RE: Detached Garage

At, 2 Cedar Close, Royston

Planning Number 2008/1276

Drawing No. 2CC/07/02REV

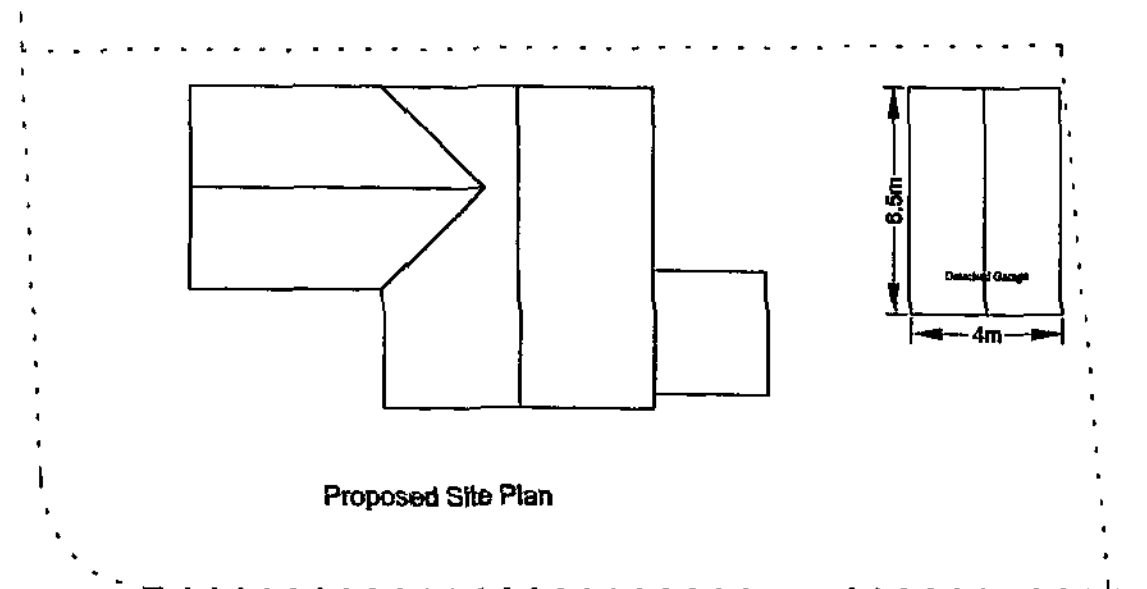
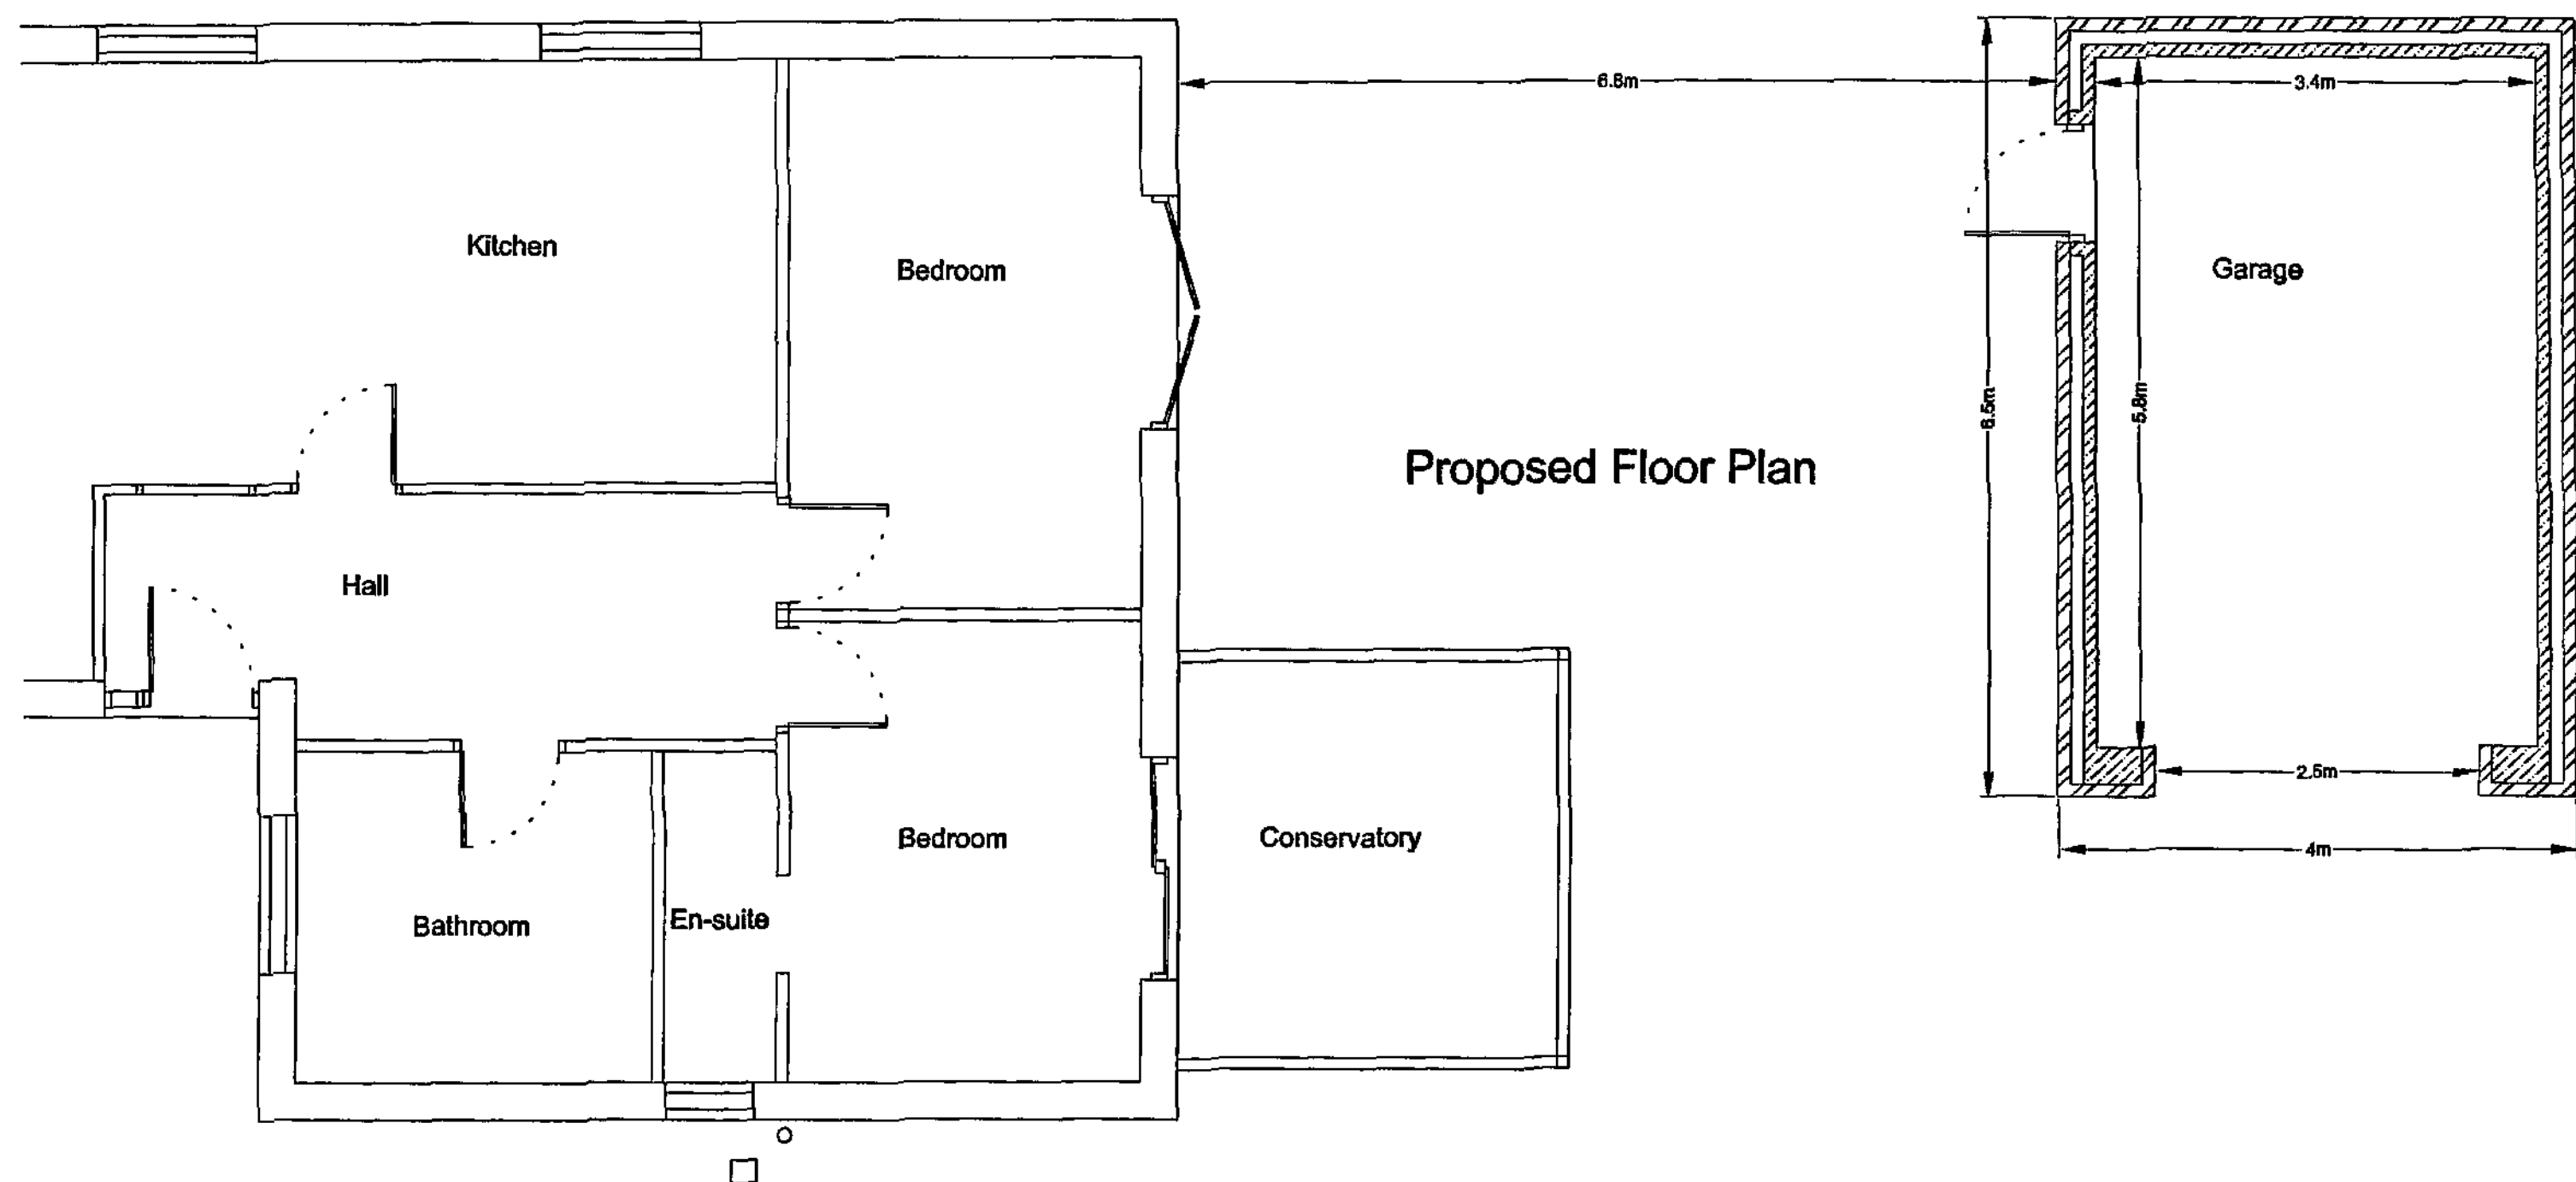
Further to the original refusal of the above and the subsequent resubmission please find enclosed 4 copies of the Fourth revised plans for the project. The size of the garage has been reduced to 6.5m in length and not 6m has recommended because the internal length would only be 5.3m if reduced to 6m which would be insufficient for a large car.
